From: Contact Centre (CRM) <contact@ribblevalley.gov.uk>
Sent: 06 February 2023 22:43
To: Planning
Subject: Planning Application Comments - 3/2022/1181 FS-Case-484533845

Planning Application Reference No.: 3/2022/1181

Address of Development: Cherry Hall, Main Street, Grindleton, BB7 4QT

Datum 28.00
South Elevation

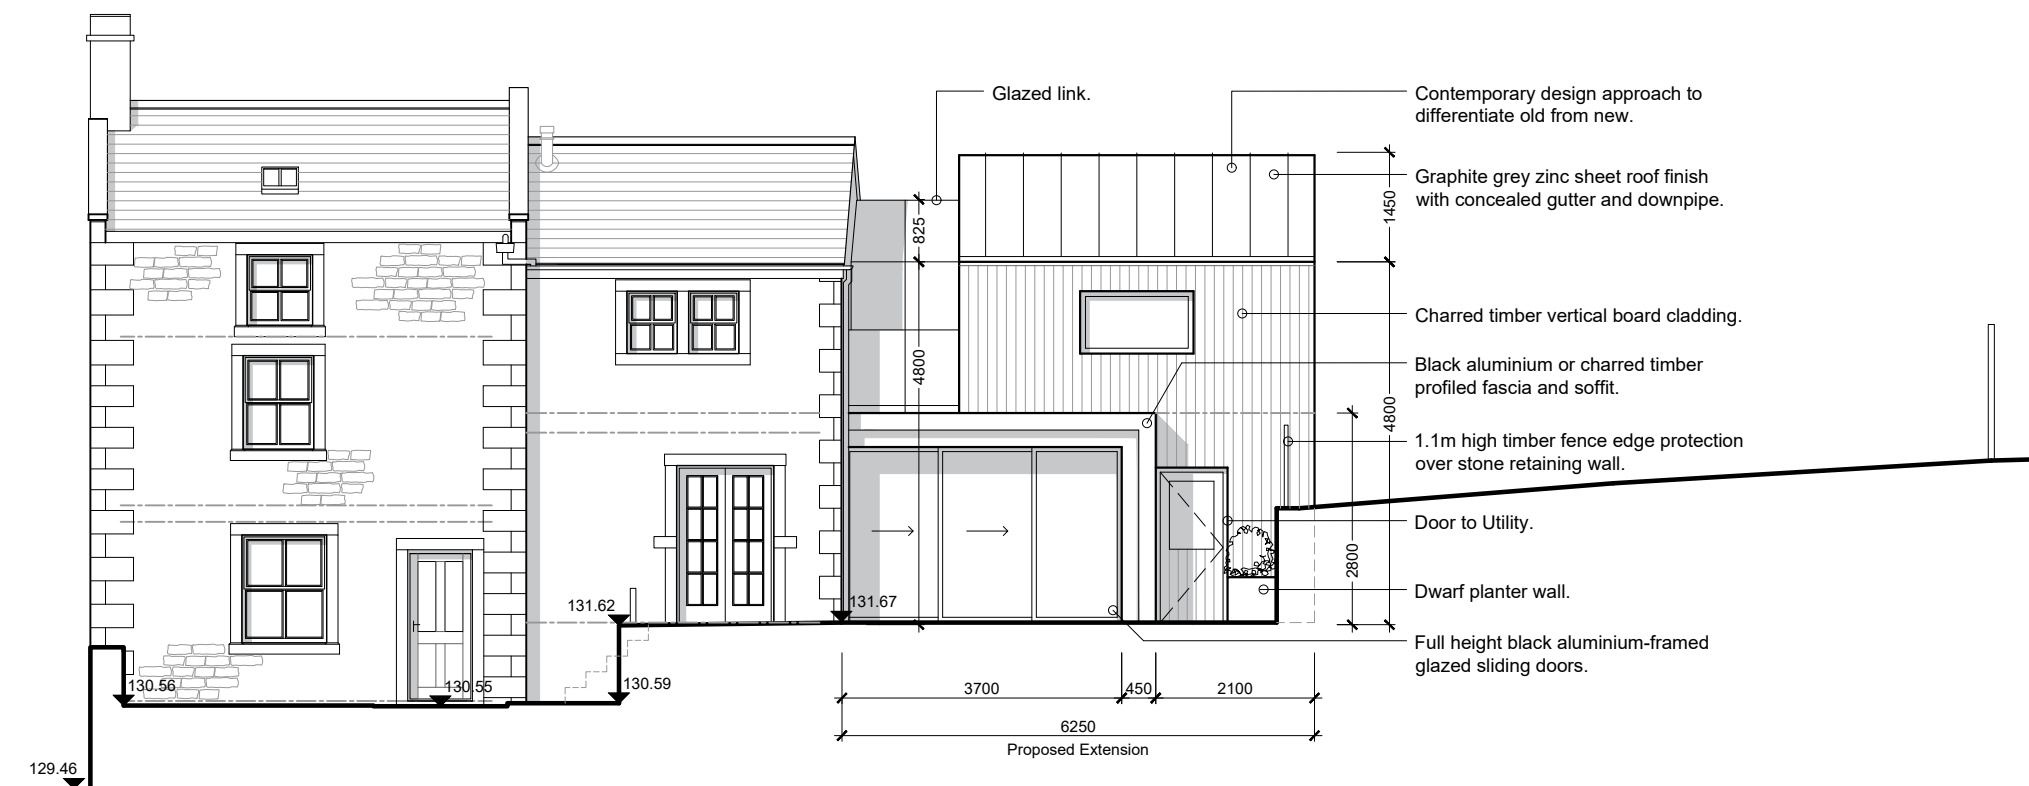
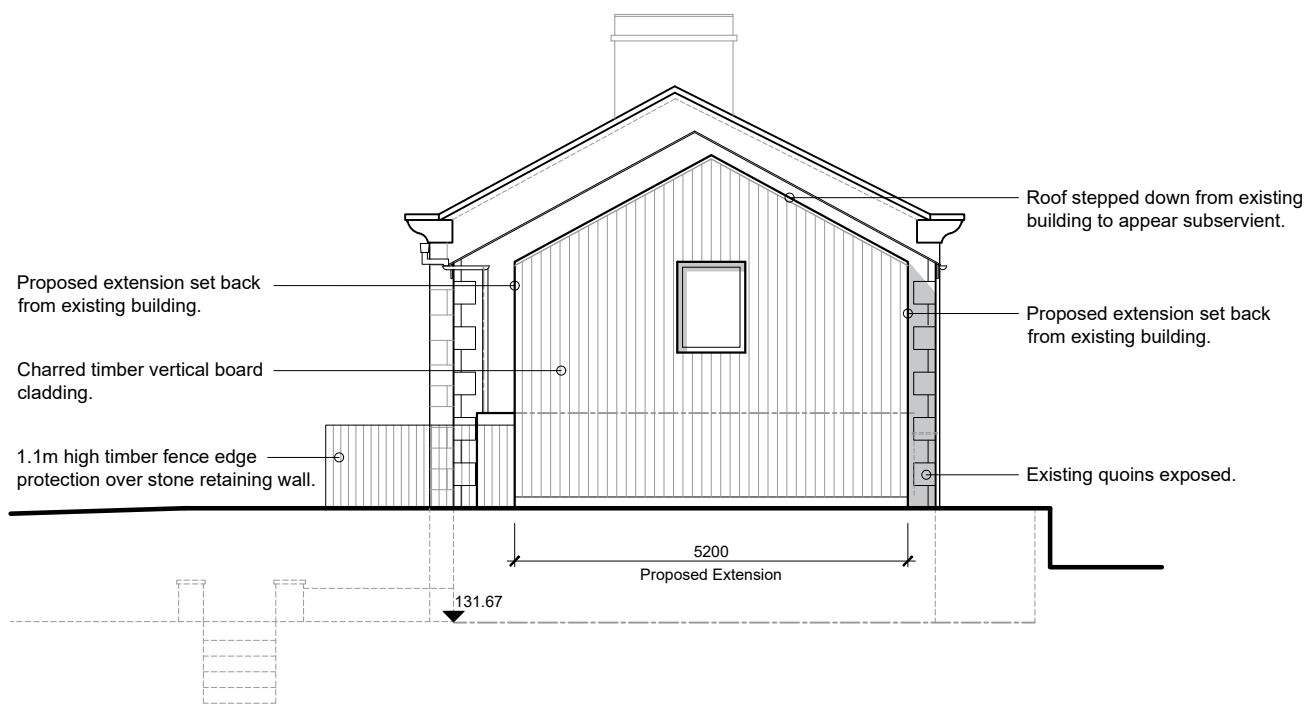
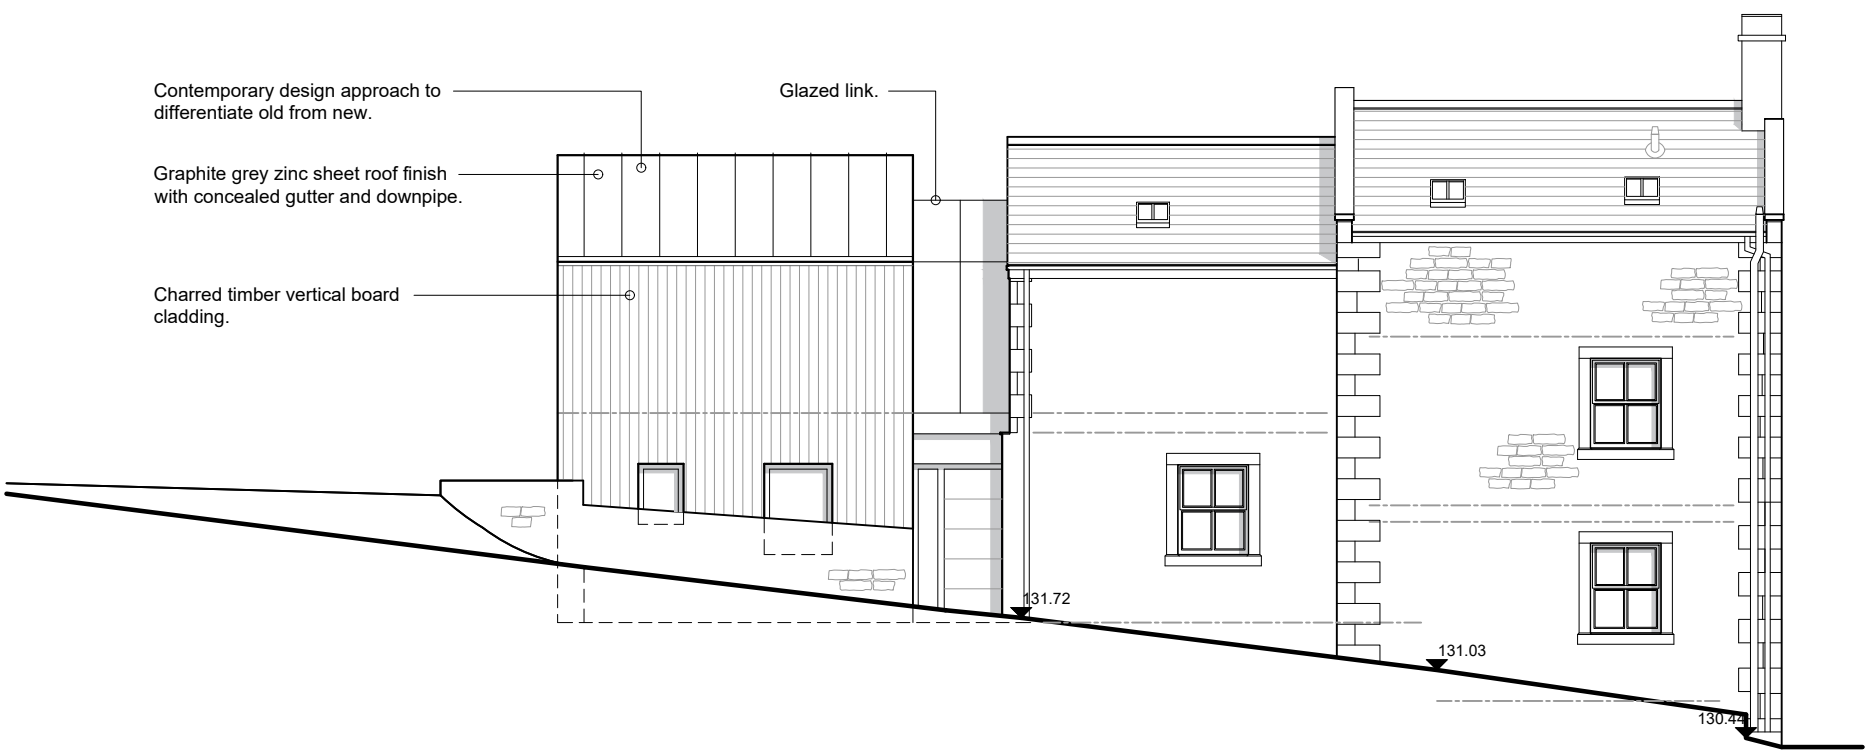
Cherry Hall also stands in a position on the road which is substantially elevated meaning any addition to the house would be dominating and highly visible, unable to be screened from the road or any of the surrounding properties. In an area of Out Standing Natural Beauty it will stand completely out of character with the surrounding properties. My final point is the major disruption to Back Lane of which 3 properties use as access (Stonelea Cottage, Beech Cottage and Hilltop) a very small lane will be completely impassable if works were allowed. Meaning these properties could not be accessed by their occupance by car, [REDACTED]

Comments: This is a significant extension to a historic building, which presents a stark contrast to the surrounding buildings - this is in a style that is not in tune with the conservation area. It seems it will be highly visible from both Main Street and the continuation of Back Lane (as a footpath paralleling Main Street), and would be yet another infill of space that will change the character of the village and lines of visibility.
